Planning Services
Town Hall
Station Road
Clacton on Sea
Essex CO15 1SE

9 August 2023

PRE-APPLICATION ENQUIRY

REFERENCE NUMBER:	23/30124/PREAPP
ENQUIRY:	PROPOSED REPLACEMENT SINGLE PRIVATE DWELLING WITH NEW RESIDENTIAL BUILDING CONTAINING 2 NO. FLATS (3 CONCEPT OPTIONS SUBMITTED).
LOCATION:	139 MARINE PARADE EAST, CLACTON ON SEA, ESSEX, CO15 5AD

**PROPOSED: MASSING (INDICATIVE)**

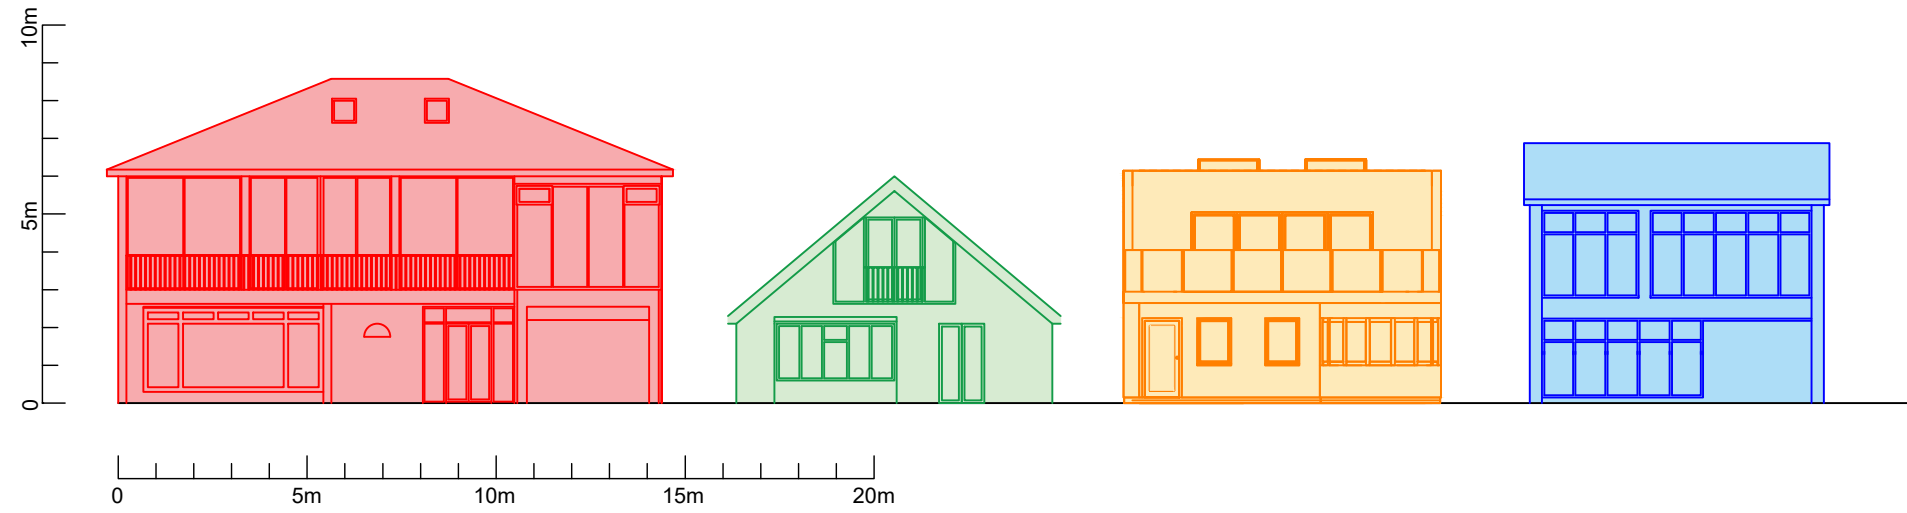
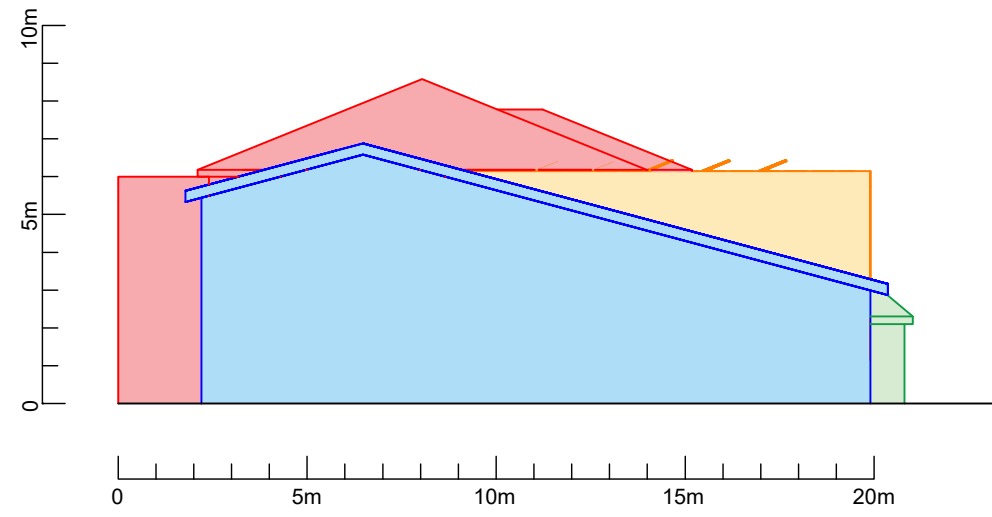
The footprint and position of the building would sit forward of both immediate neighbouring buildings, and beyond the rear elevation of the neighbouring property at no. 137 Marine Parade East (shown in green in the street scene plans above).

The prevailing character in this locality is that of single, 1.5 and 2 storey dwellings. All 3 concepts would result in a 3-storey building in place of a modest single storey property with a fully hipped roof arrangement.

All 3 concepts are higher than the immediate buildings, including the highest example at 135 Marine Parade (shown in green in the street scene plans above). All the options will therefore dominate the neighbouring buildings in a harmful way.

For these reasons, having regard to the adjacent built form and prevailing character, the height, bulk, scale and massing of all 3 design concepts presented would be out of keeping. The development would result in an excessively prominent and visually intrusive development being harmful to the character and appearance of the area.
